SPR EA1N and EA2 PROJECTS

SASES DEADLINE 2 – COMMENTS ON EXQ 1 RESPONSES - 1.9 LAND USE

Interested Party: SASES

## Indicative Construction Plan

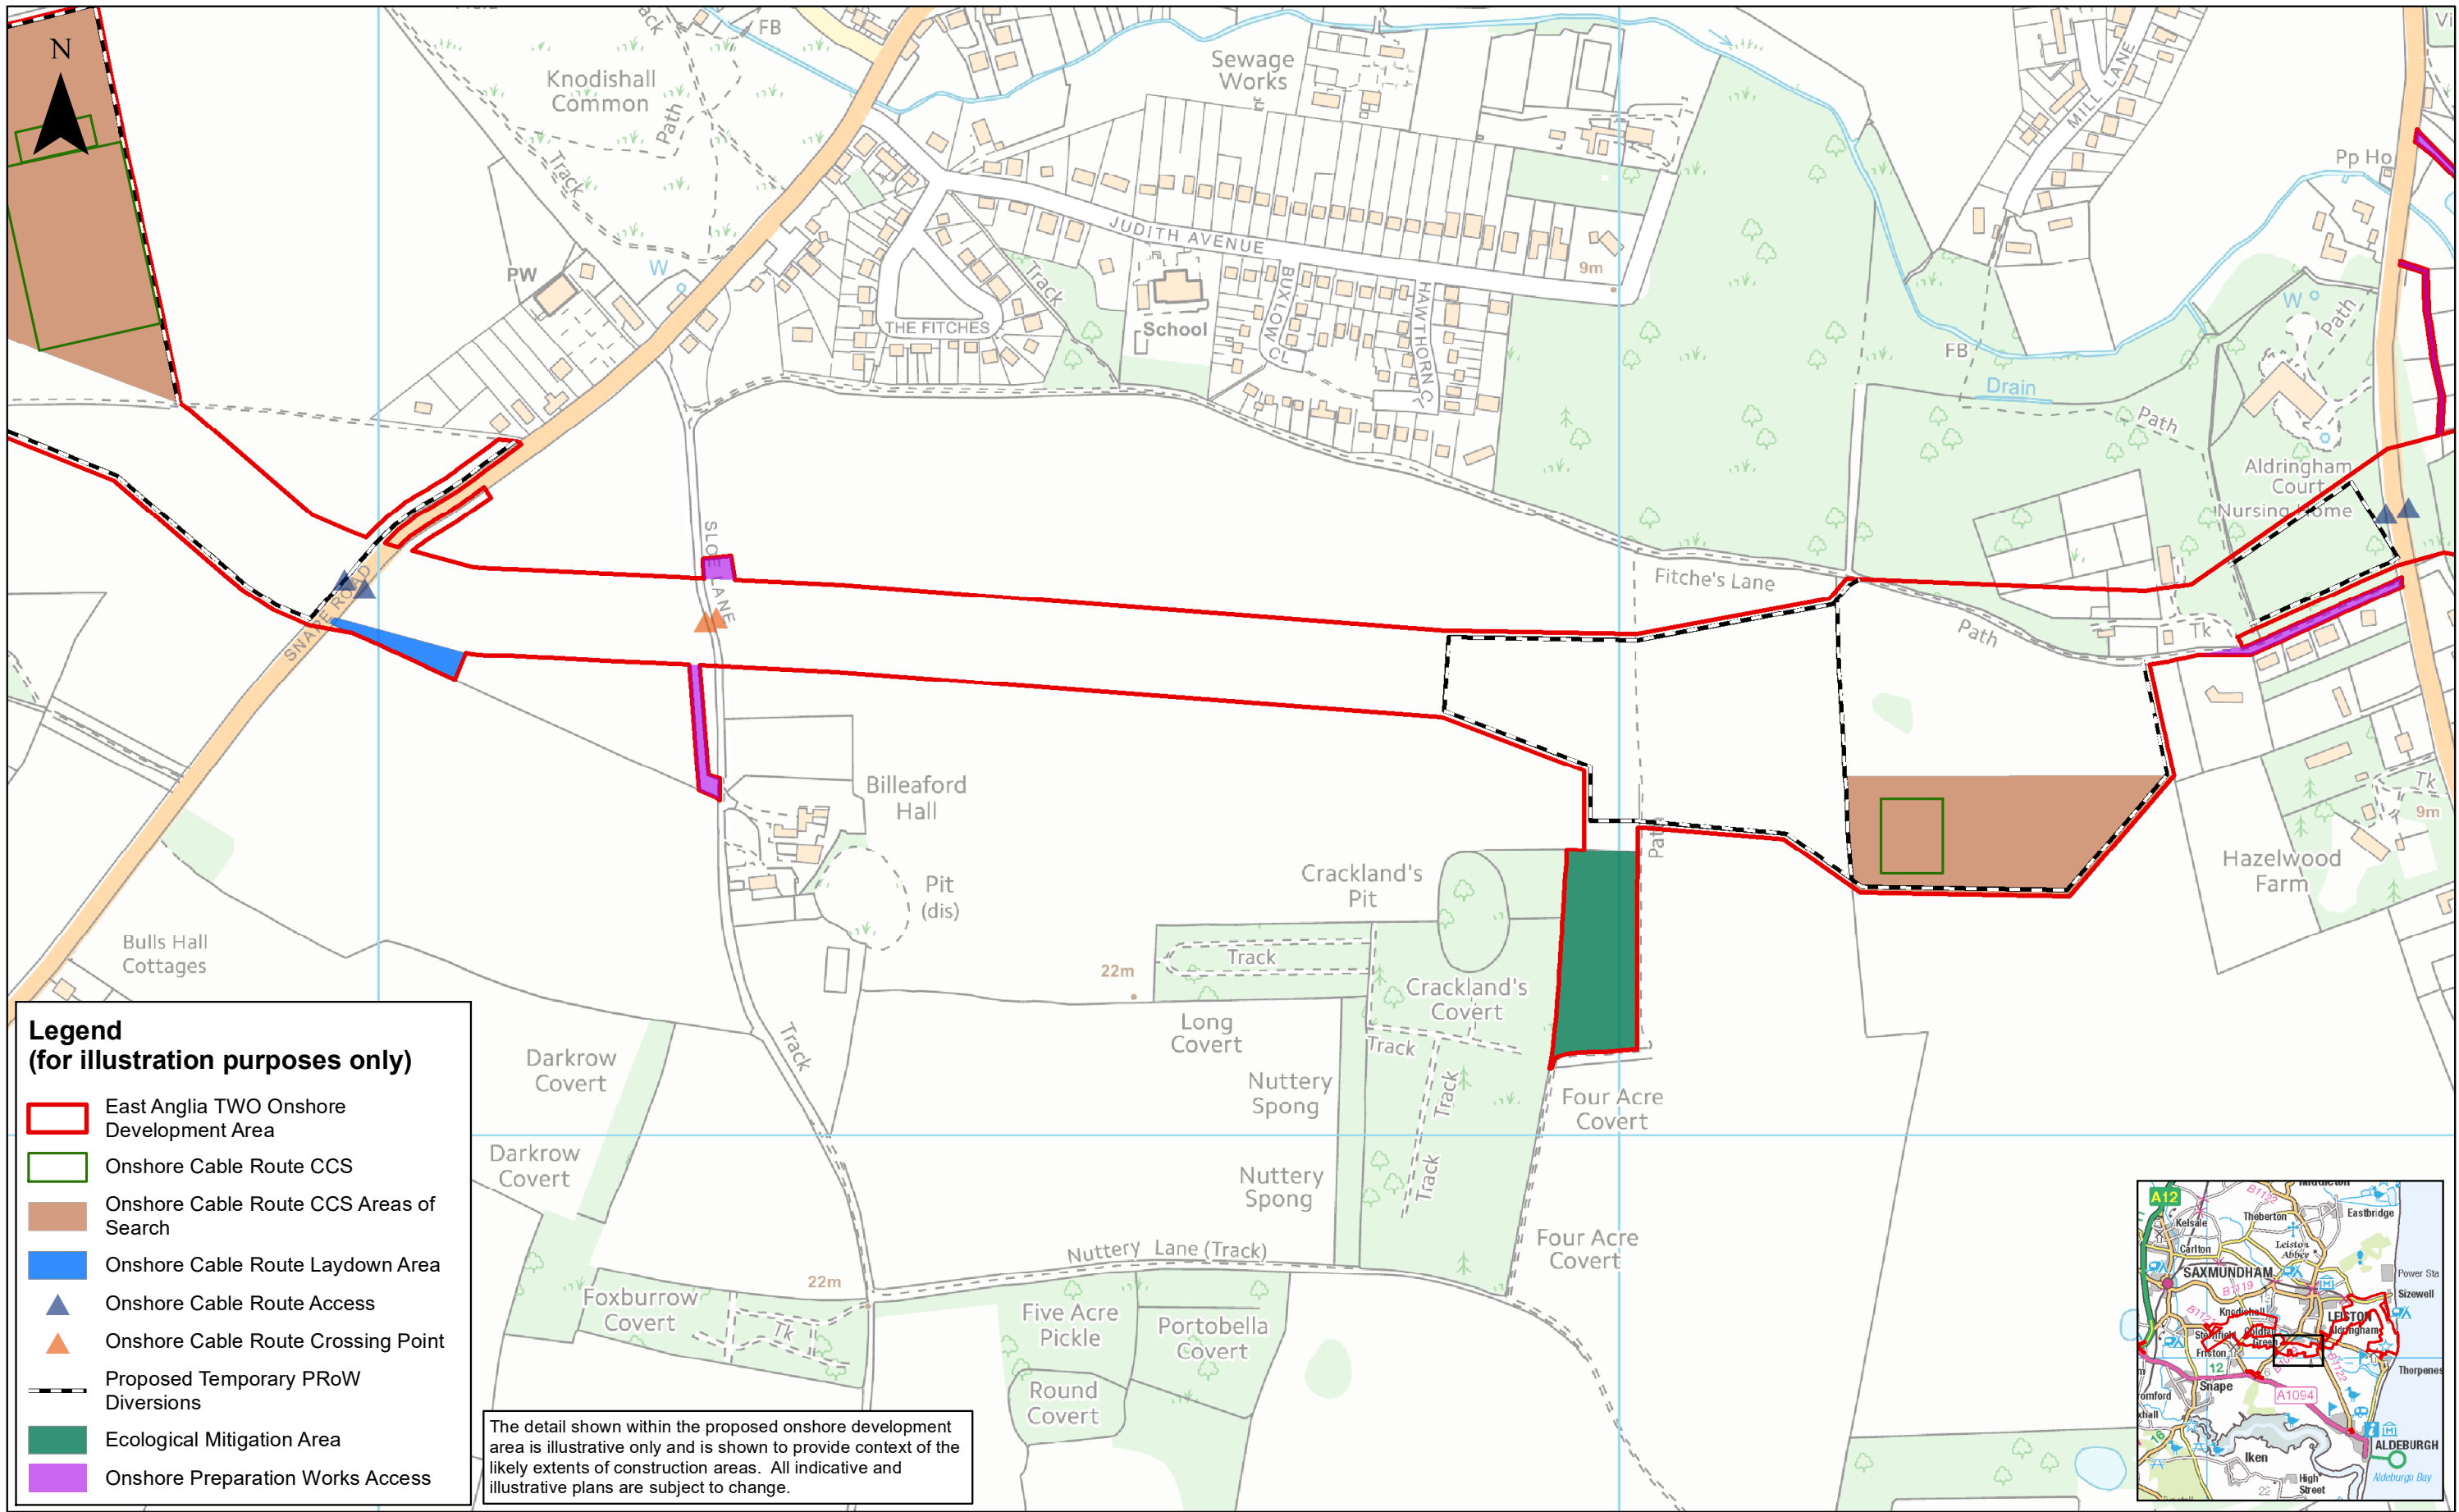
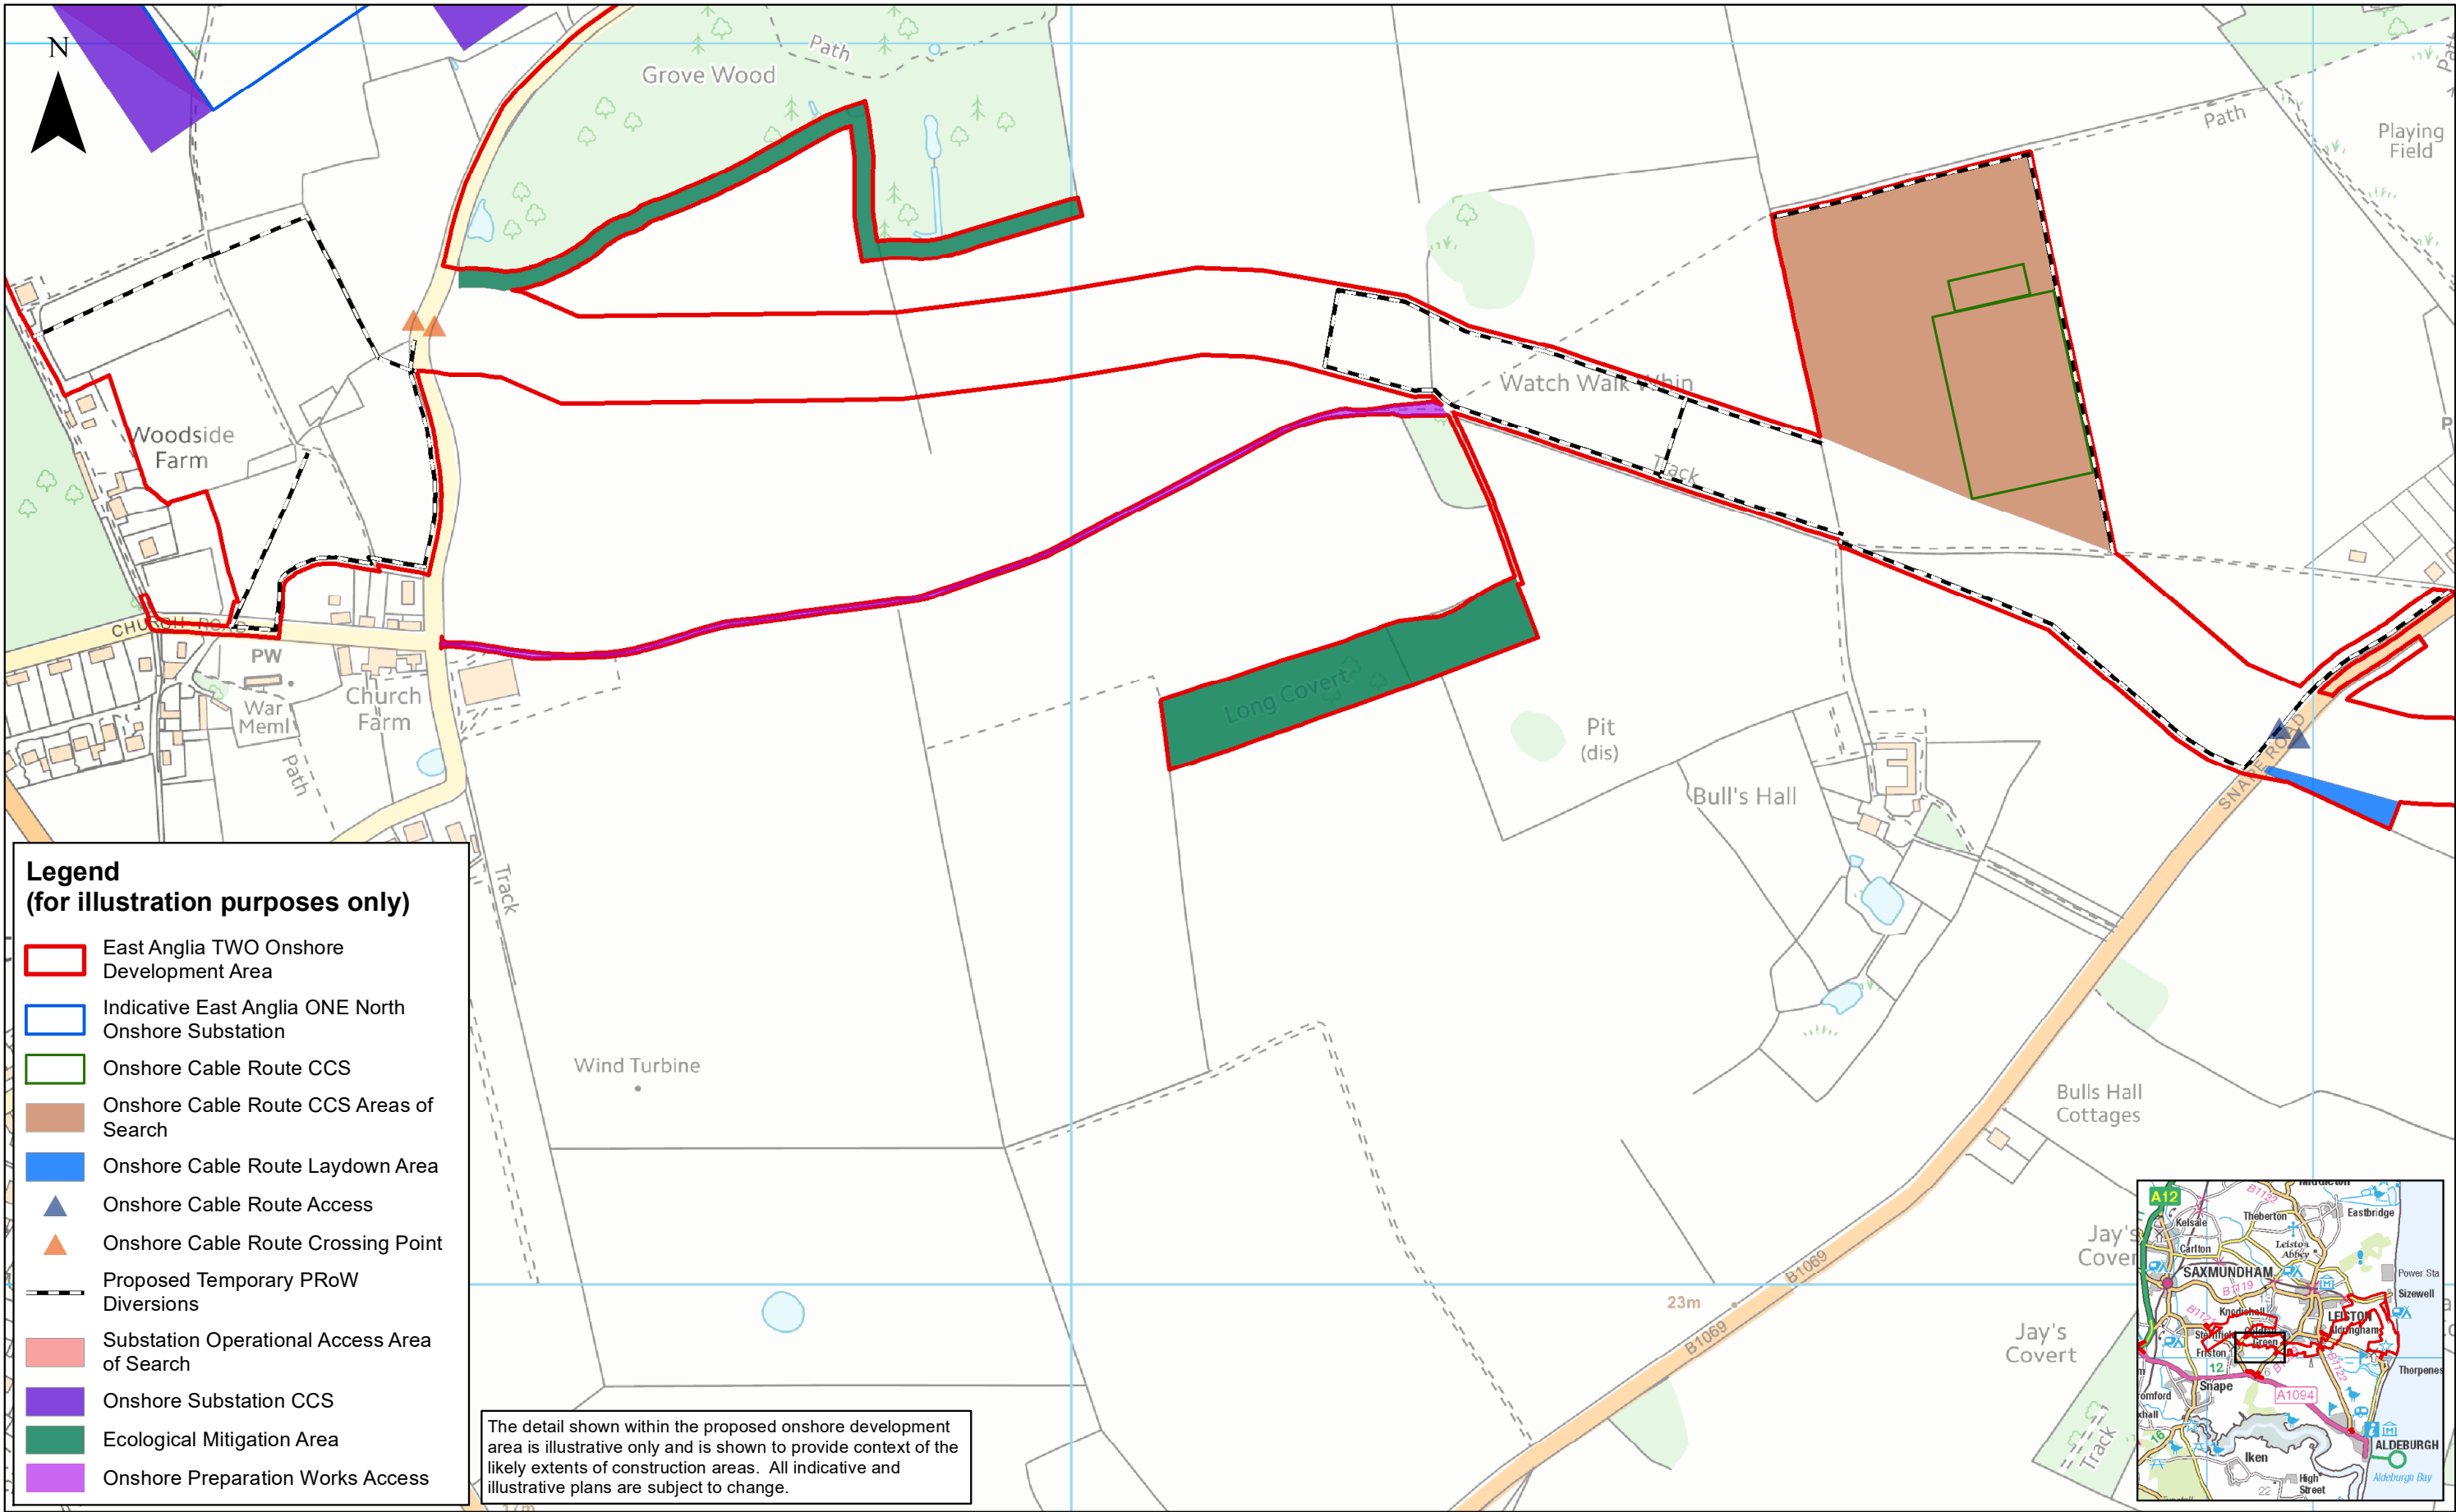
<p>1.9.21 PRoW Strategy</p>	<p>Explain what measures you will take to avoid nuisance and ensure the safety, amenity and quiet enjoyment by those using them in the vicinity of the construction works, with particular reference to the Suffolk Coastal Path</p>	<p>The Applicant has answered this question mainly in relation to the landfall location at Thorpeness.</p>	<p>SASES asks for an explanation of what measures will be taken with regard to the PRoW network on the substation site at Friston during the construction period. Specifically what footpaths will be open and available for use and how safety, amenity and quiet enjoyment can be maintained.</p>
